From: patrick.barry [REDACTED]
Sent: 18 July 2017 11:13
To: Andrew Wood
Cc: Stewart Rose; Dominic Smith
Subject: FW: Y/5/17/OUT Cinder's Lane, Yapton- RSA/TRO

There has been some confusion on documents submitted to address comments from WSCC Highways. I have reviewed the online records and note that the updated Transport Statement (rev 7) (including tracking plans at Appendix D as requested by WSCC) and the updated Road Safety Audit (addressing previous typo referring to 'Midhurst Road') do not appear to have been uploaded.

GENERAL ARRANGEMENT- SITE ACCESS ROAD (SCALE 1:500)

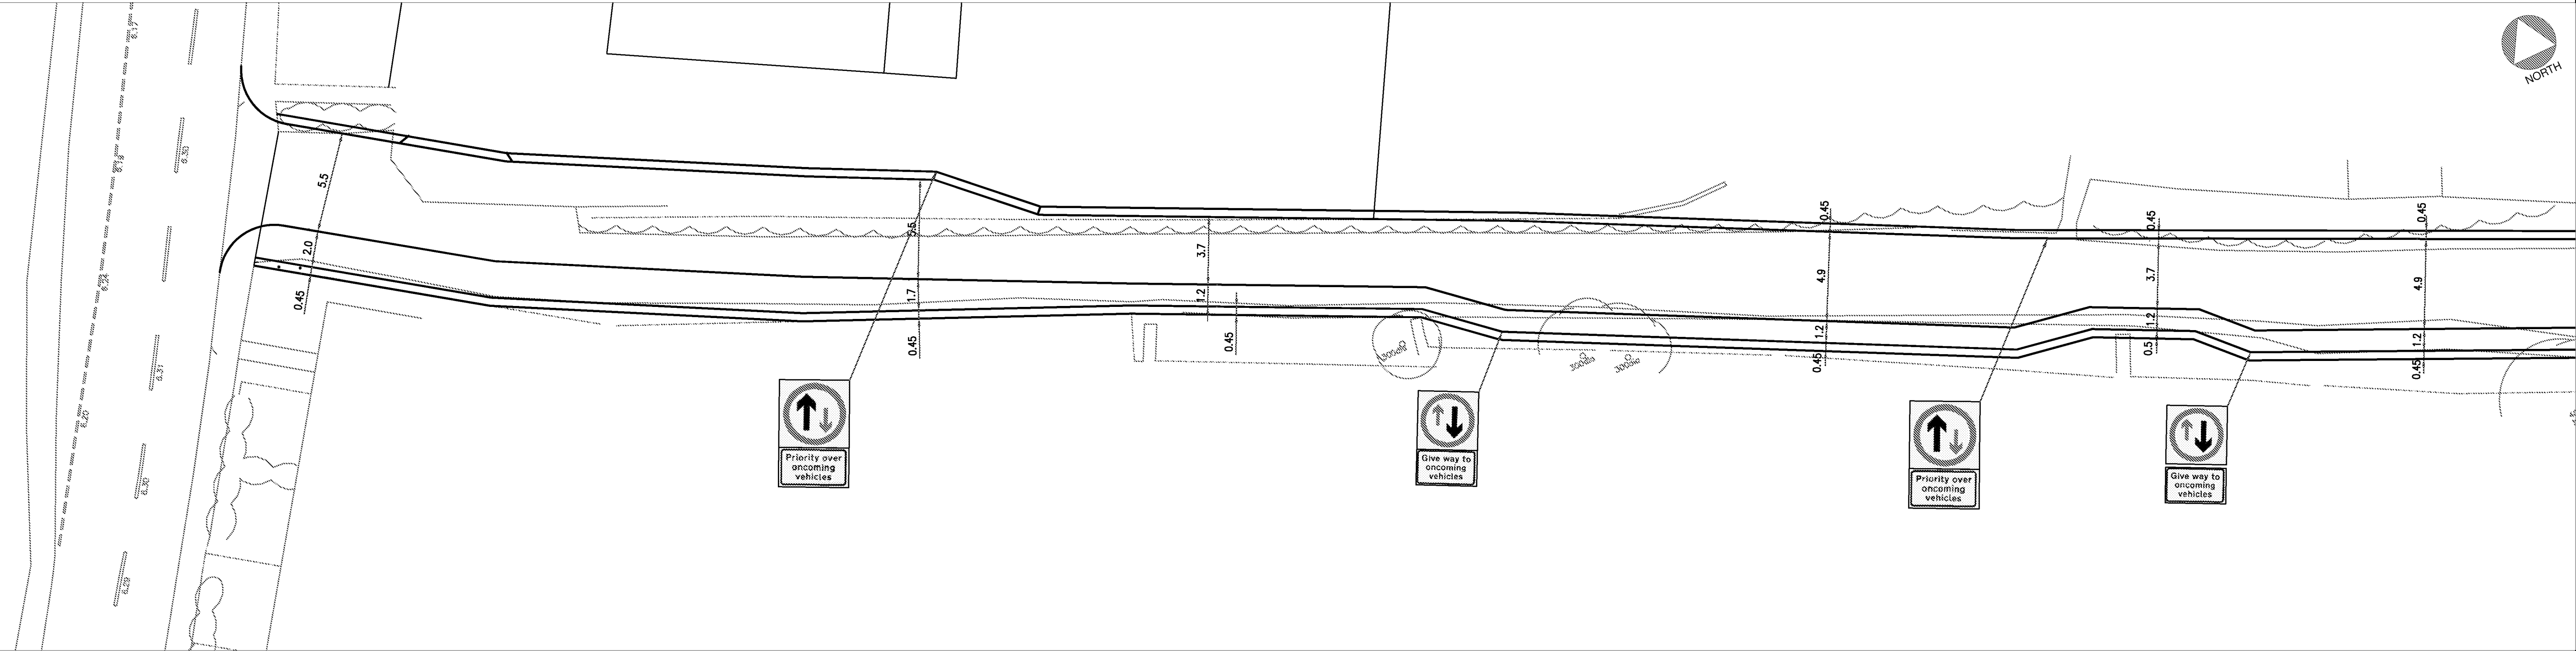
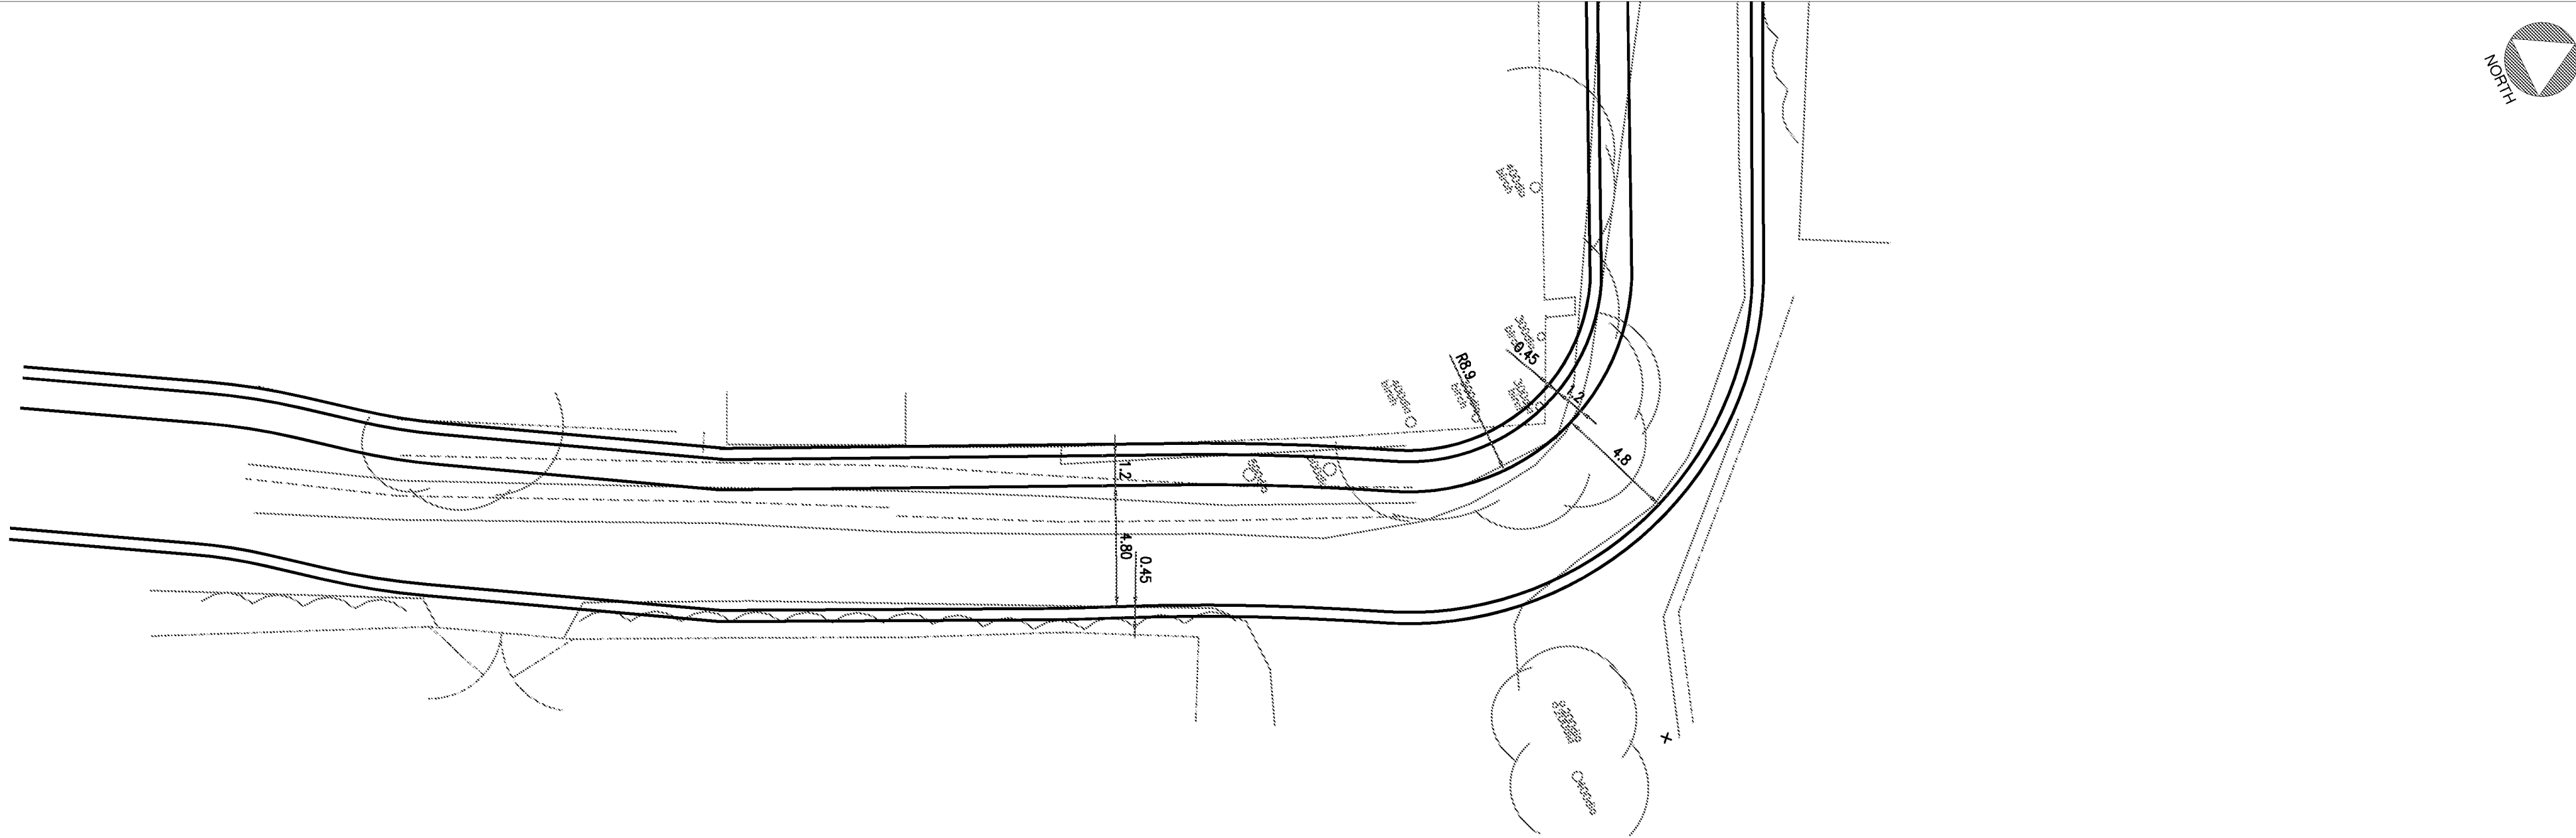
The only comment relating to the arrangement on P4 is the achievable visibility from the surgery especially if the boundary of this property immediately abuts the access road. It's unclear if any consideration has been given to the boundary treatment of this property obstructing visibility. A solution to this would be to place the footway on the north rather than the south side of the carriageway, however this will then impact upon the priority give way arrangement, which would still be required because of the pinch points.

I would suggest that a segregated foot/carriageway arrangement would be more suitable along the access road rather than a shared surface.

SITE ACCESS ROAD VISIBILITY SPLAY (SCALE 1:200)

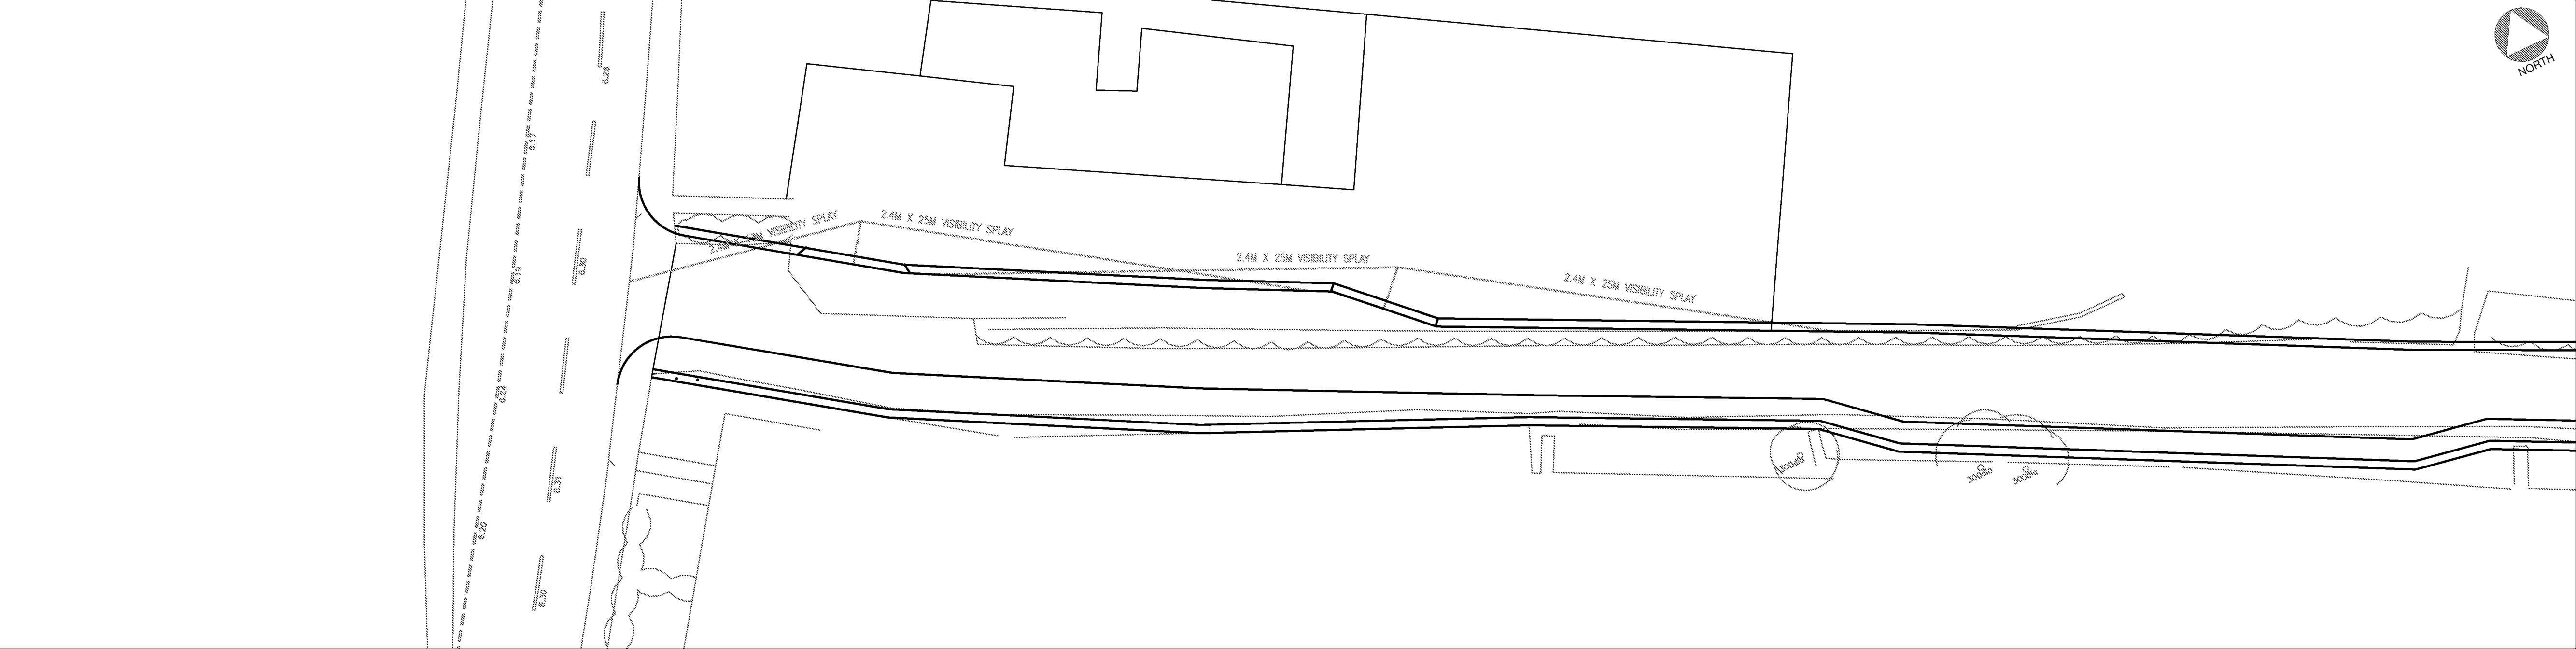
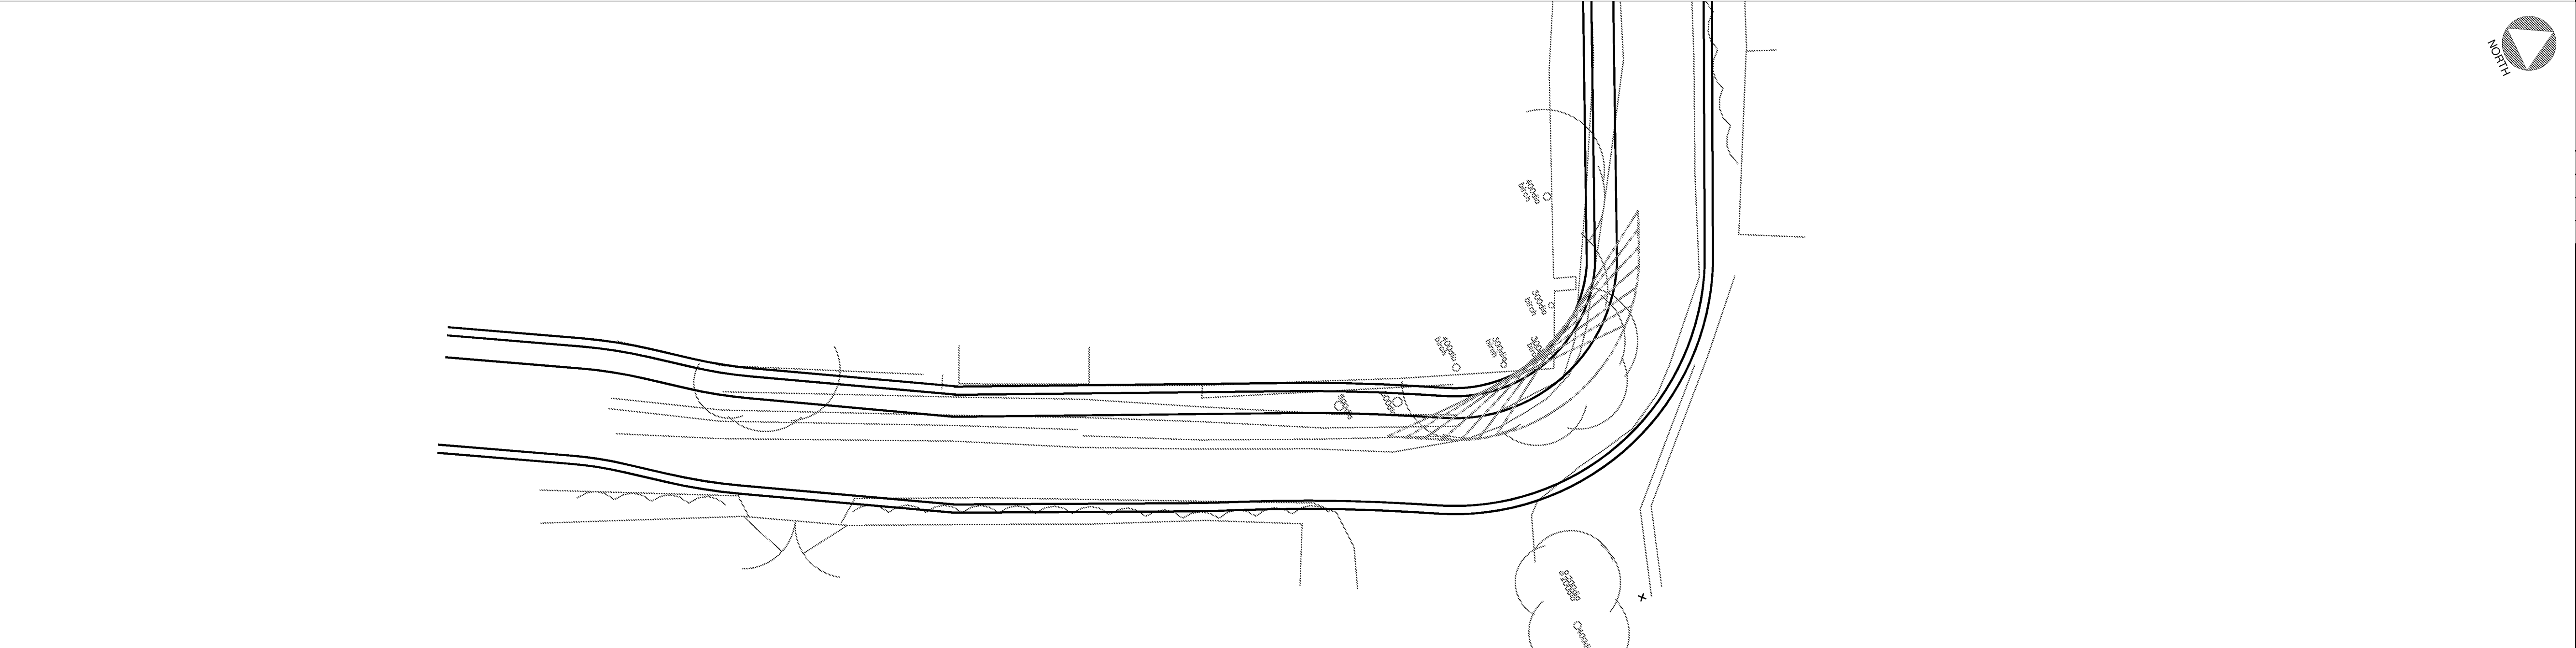
Thank you for your feedback. The boundary between the surgery and Cinder's Lane will be a hedge /fence, kept under 600mm in height. We can achieve a 2.4m x 25m visibility splay in both directions, falling within the Surgery land and Cinder's Lane (as shown in the attached drawing). However, there appears to be a couple of outstanding aspects of the proposal that we would like to receive clarification on:

At the junction of Cinder's Lane / B2132, our observations indicate that vehicles park on-street within the site access' visibility splay. Given the informal on-street parking and level of activity in this area is conducive to lower vehicle speeds, we consider MfS and WSCC guidance that "in some circumstances where speeds are low, some encroachment may be acceptable" to be applicable in this instance. We note that visibility extends over the front of the doctor's surgery- this land would be within our control. Whilst the visibility has been measured to the full 43m for a 30mph speed limit, the visibility splay has been measured to an 1m offset in the secondary direction in order to take into account vehicles parked on-street in this location.

The access road features a sharp bend, where forward visibility is reduced as shown in the attached drawing. We consider there to be a reduced requirement for forward visibility in this instance due to the very low speed (design speed of 12.5mph) of vehicles approaching this corner and likely low volumes of traffic for a development of this nature. In addition, parking can be prohibited on this road, which is to remain private, to ensure that forward visibility is not blocked. This could be supported by traffic calming measures, such as a raised table in the corner to signify the presence of the corner and lower vehicle speeds.

Such matters would be assessed as part of the Stage One RSA. If this is raised as a problem, the development would need to fund a TRO. The exact extents of the waiting restrictions would be agreed if this is raised as a problem.

MfS recognises that a reduction in forward visibility encourages drivers to use caution, and therefore slow down. The proposed access road is sufficient to enable two opposing cars to pass, so forward visibility is not necessarily required to avoid conflict. In principle such a reduction would be accepted.
